COLORADO
Department of Transportation

SH24G
El Paso County

RE: Meadow Lake Airport Expansion_AASI181 - Revised to include Corridor Comments

AIRPORT LAYOUT PLAN -
EXISTING

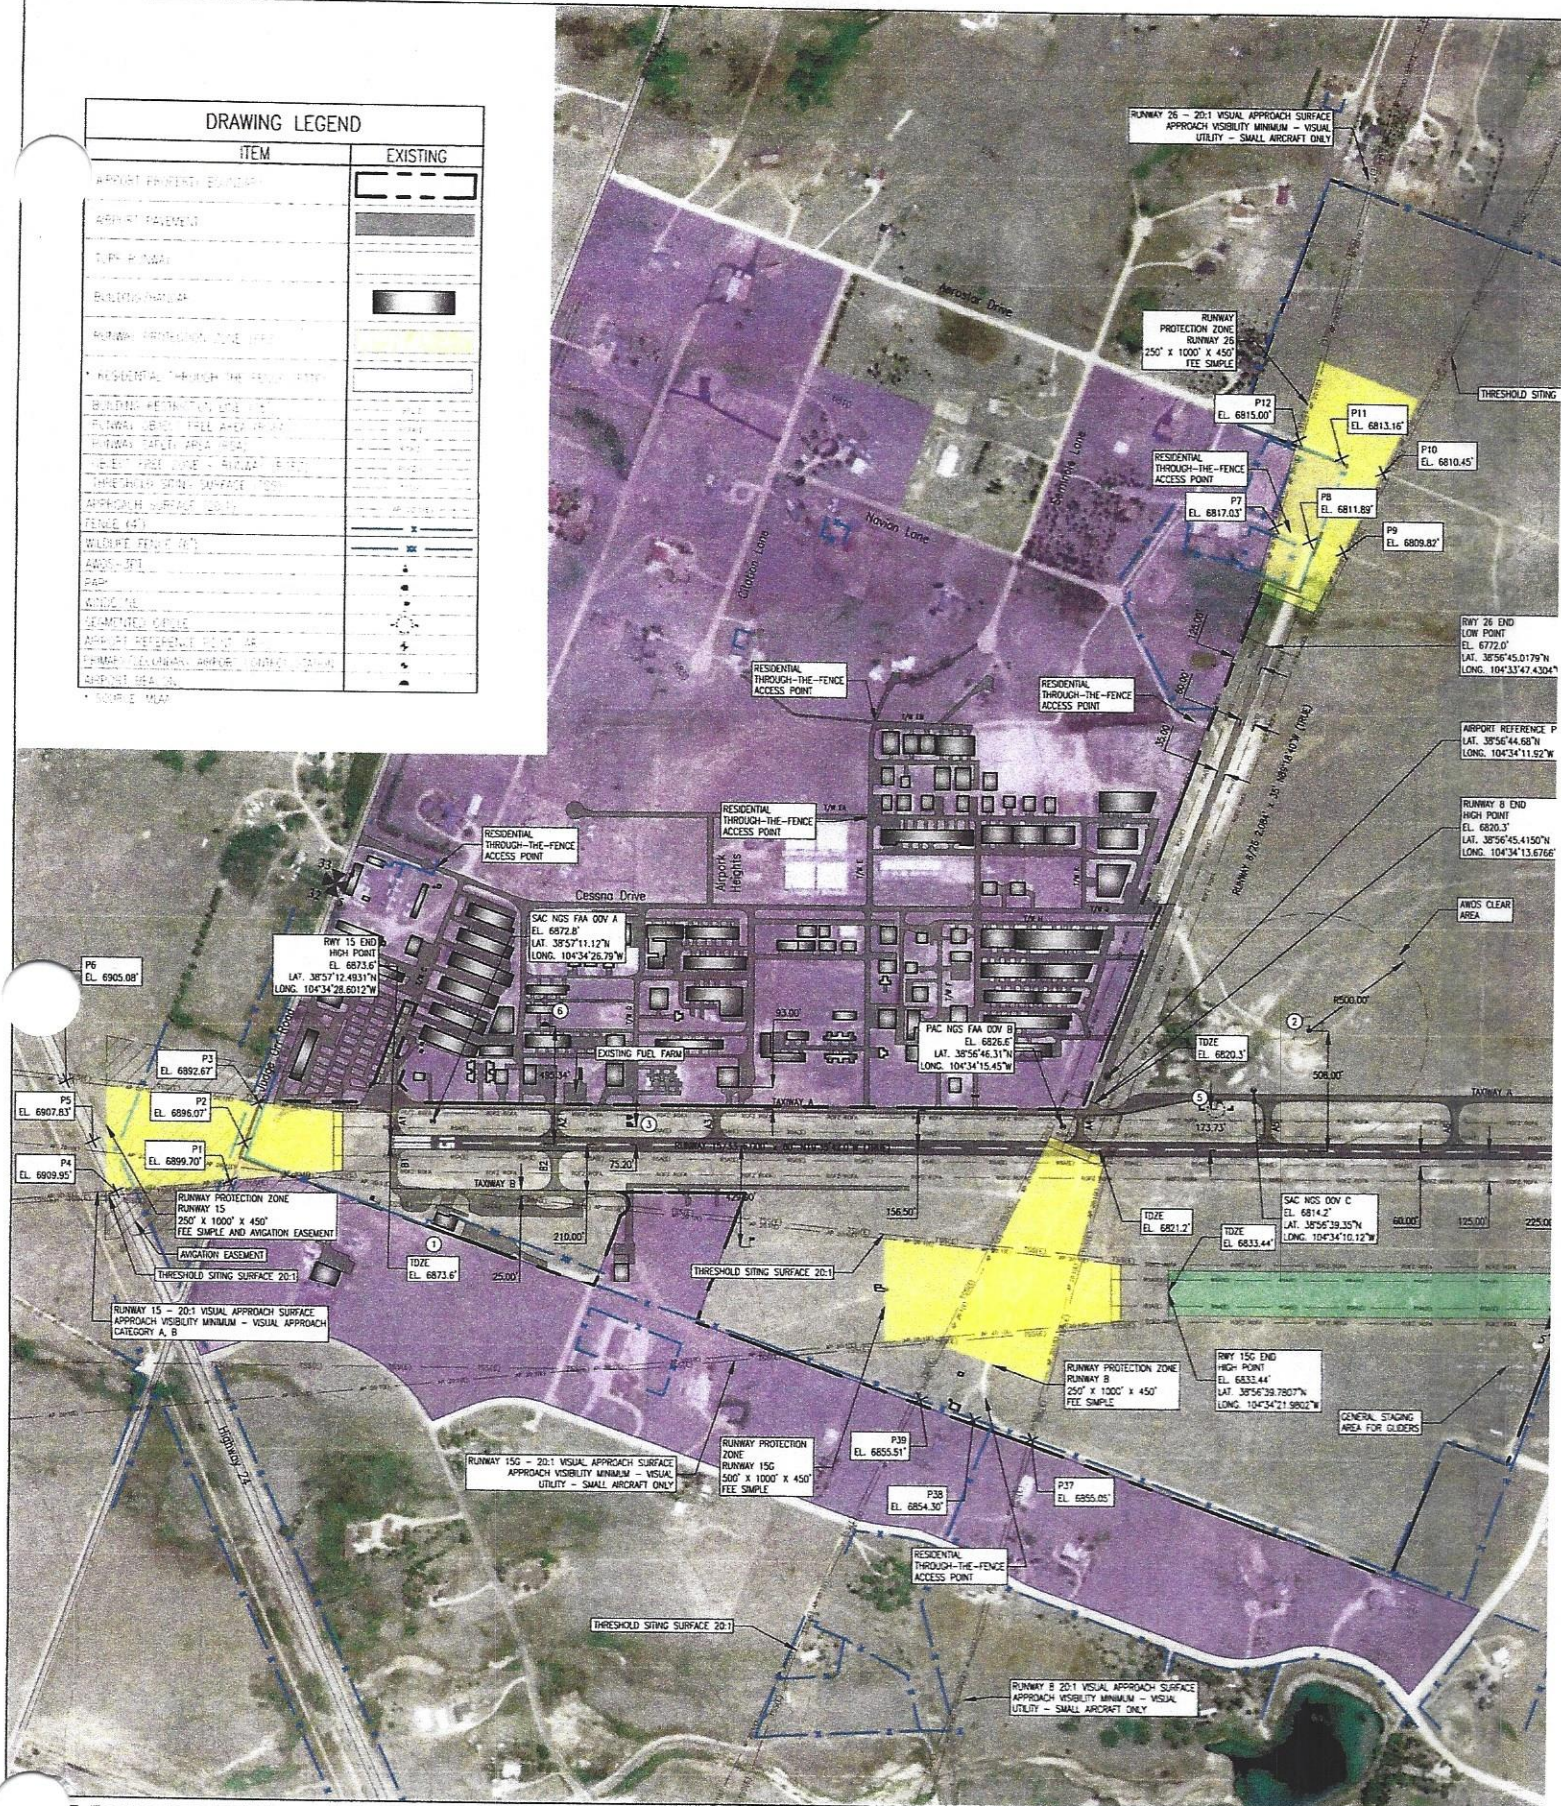
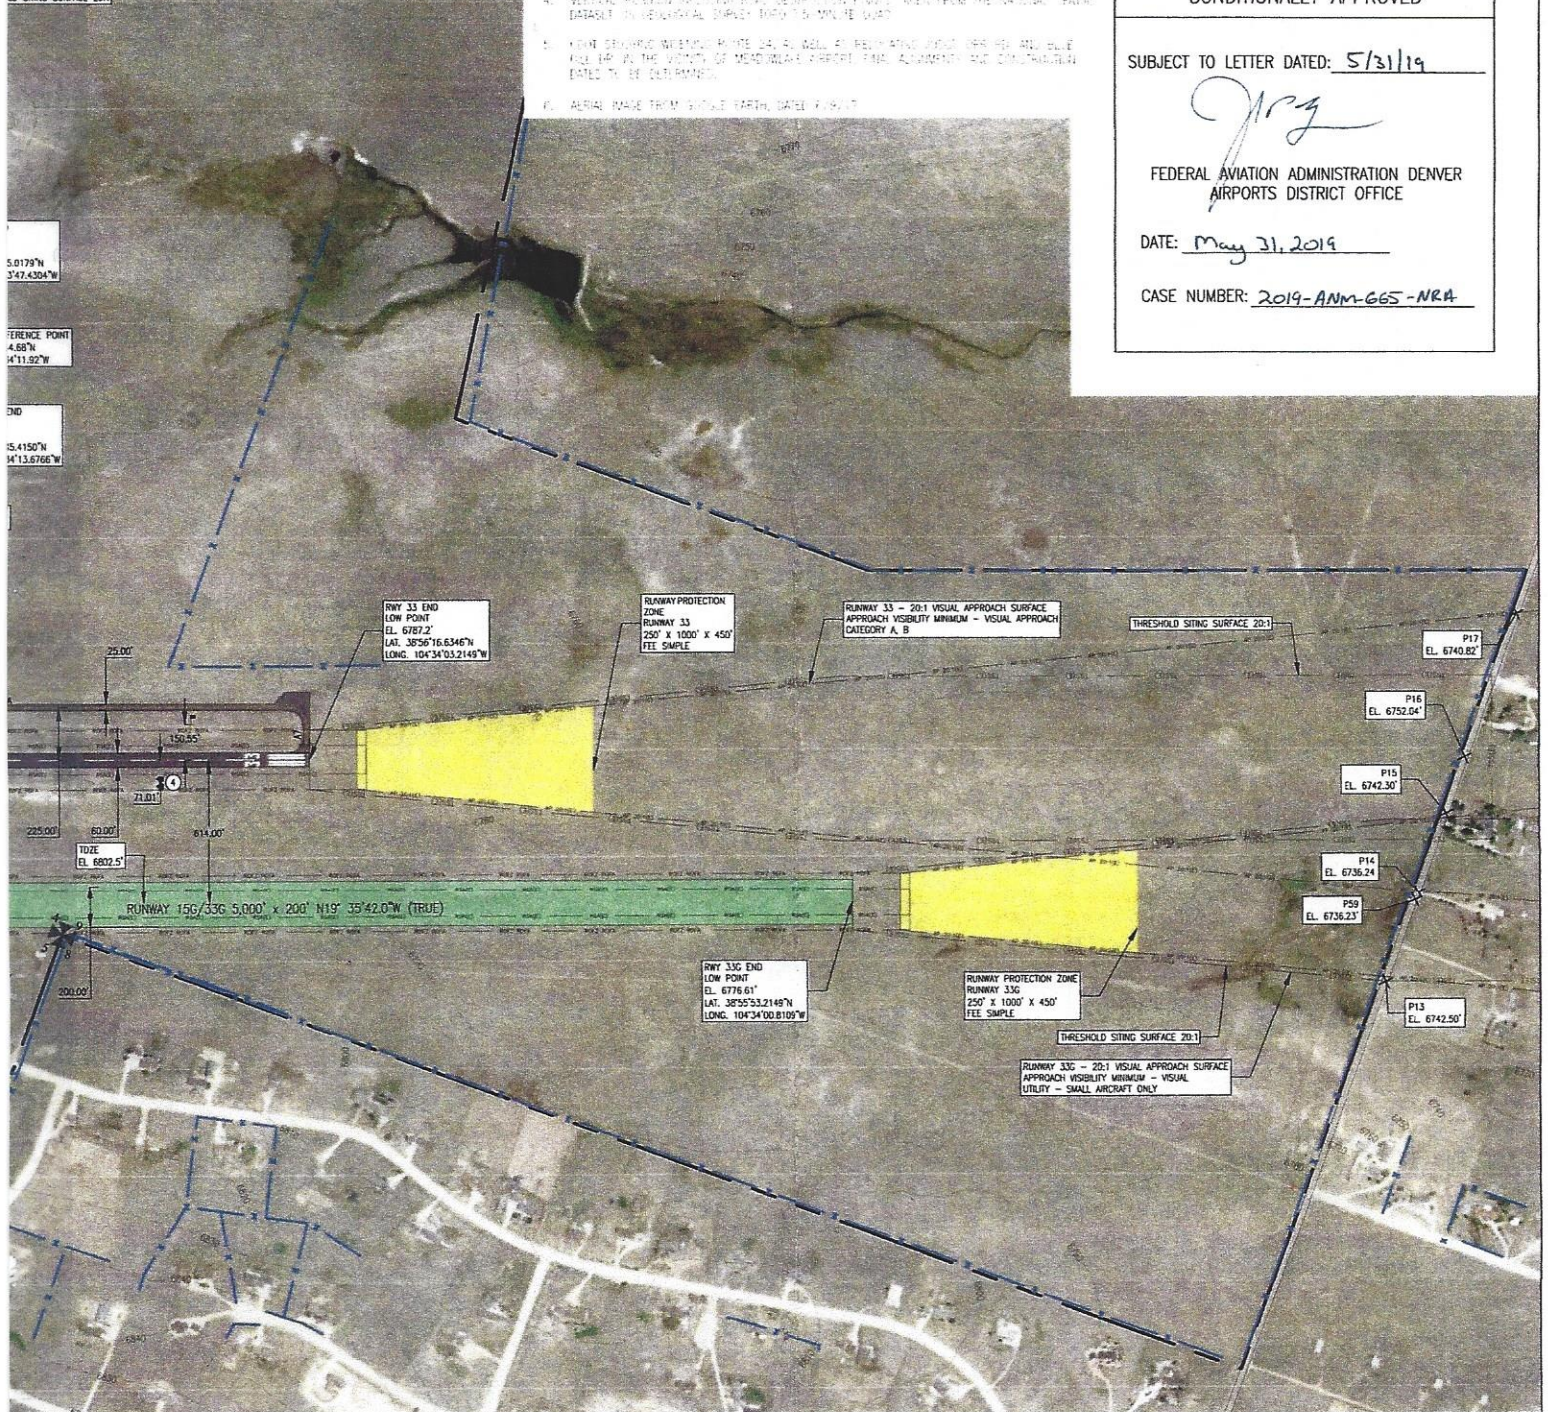
- 4) The Airport Layout Plan and Airport Master Plan have a few references to the widening of US 24 and/or the Judge Orr intersection improvements being "on hold indefinitely" with no schedule to move forward. In fact CDOT does have a plan to widen US24 and this was one of the November Ballot Projects.
They should still plan to not preclude or make it more difficult to move forward with those projects.
